# KITTTITAS COUNTY COMMUNITY DEVELOPMENT SERVICES

**RE: Transmittal of Comments – ATT Teanaway Cell Tower Transmittal of Comments and Request for Additional Information (ACU-19-00001)**

RE: WDFW Comments on AT&T Teanaway Cell Tower ACU-19-00001

SHEET TITLE
 ELEVATIONS

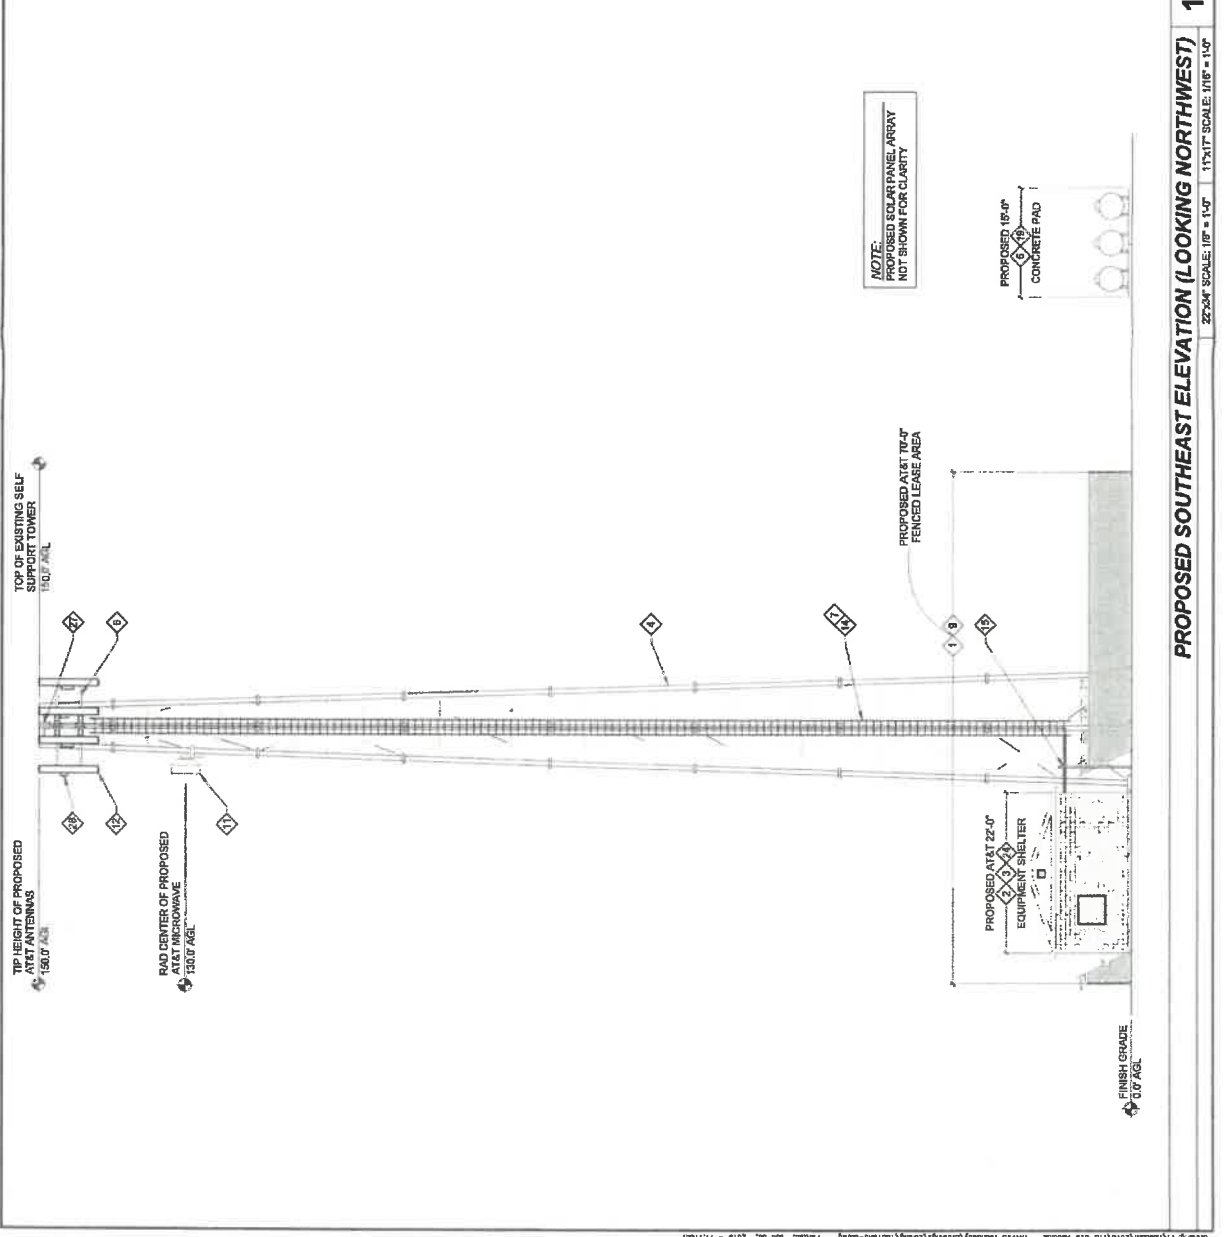
6. Aesthetics, to make the tower more easily blend into the forested landscape, the project should consider replacing the proposed lattice tower with a monopine tower which is more aesthetically in line with the surrounding forest for both habitat and recreational interests.

**SHEET TITLE**  
 ENLARGED SITE PLAN

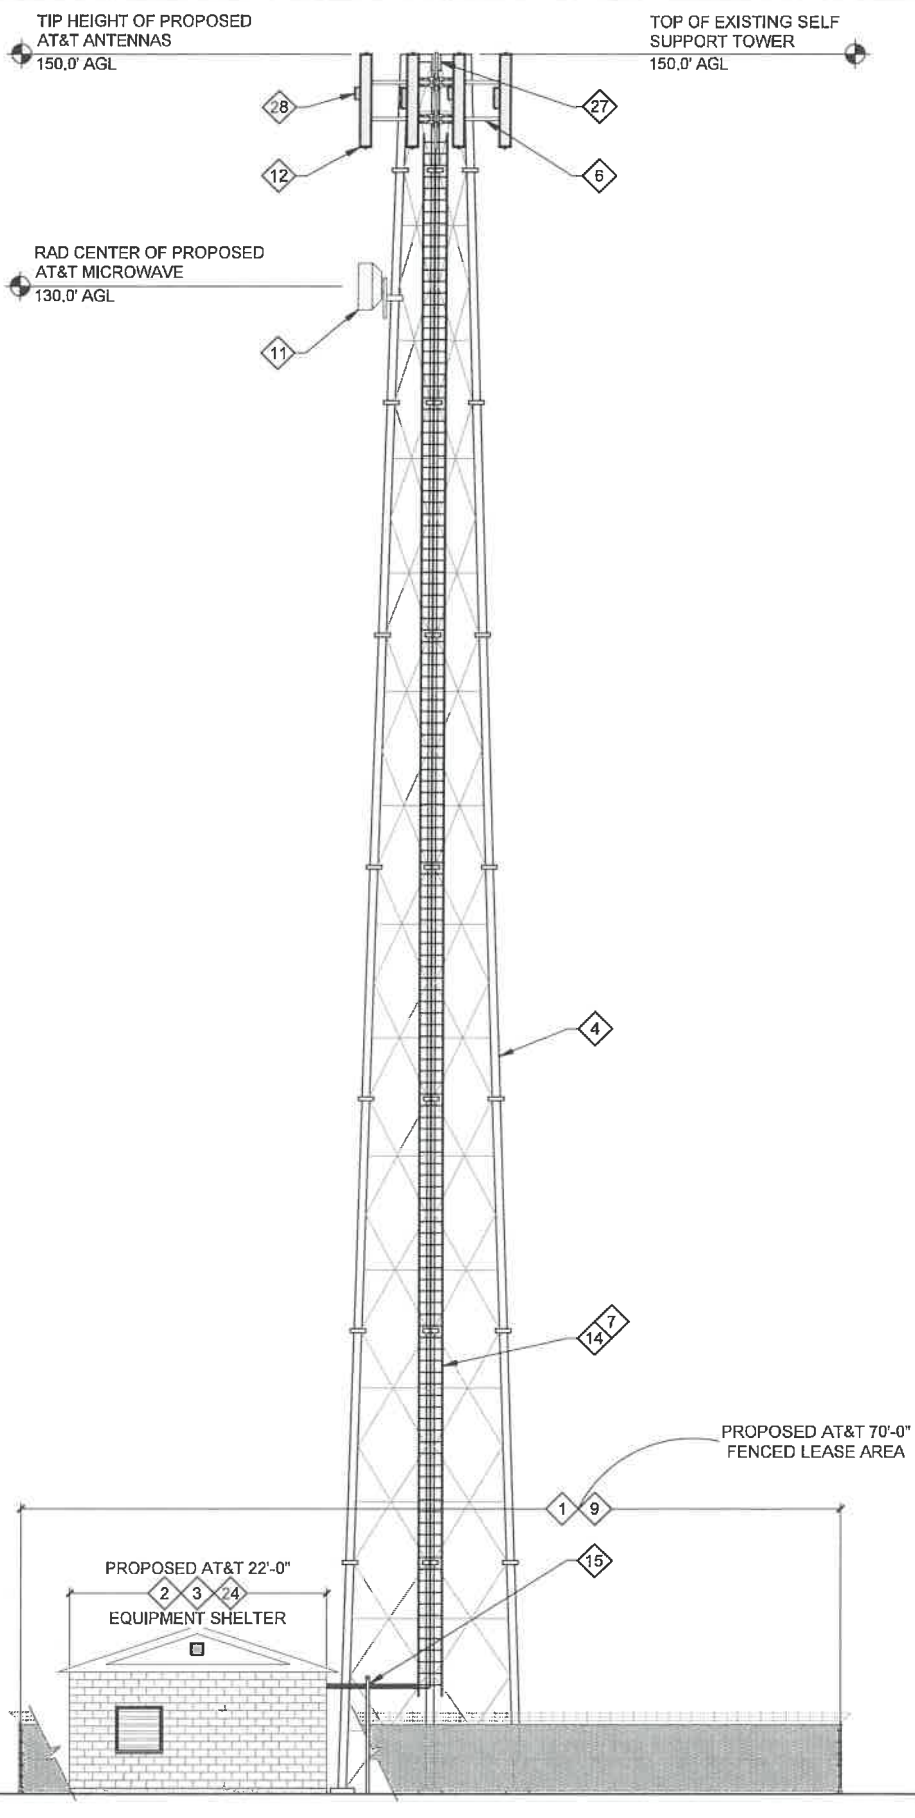
2. The project needs to provide more details on the facilities;
  - a. more details on perimeter security fence installed (it needs to be at least 8 foot in height to exclude deer and elk and of a design that will not harm wildlife, single strand barb wire or no top wire),

- b. explanation of why the solar panel array and the propane tank is outside of the fence-this is public land, so are there concerns over public having access to either the panels or the propane tanks,

- c. clarification on the generator plan, the SEPA checklist states a diesel generator, yet the plans show a propane generator and how do the solar panel array factor into the plan,

- d. details on proposed retaining wall for slope stability on the western end, such as a grading plan, what is the footprint disturbance that will need to be restored.

3. Weed control; the project is installing a weed block in their fenced area, but no details on how any other disturbed land will be managed for weed control.
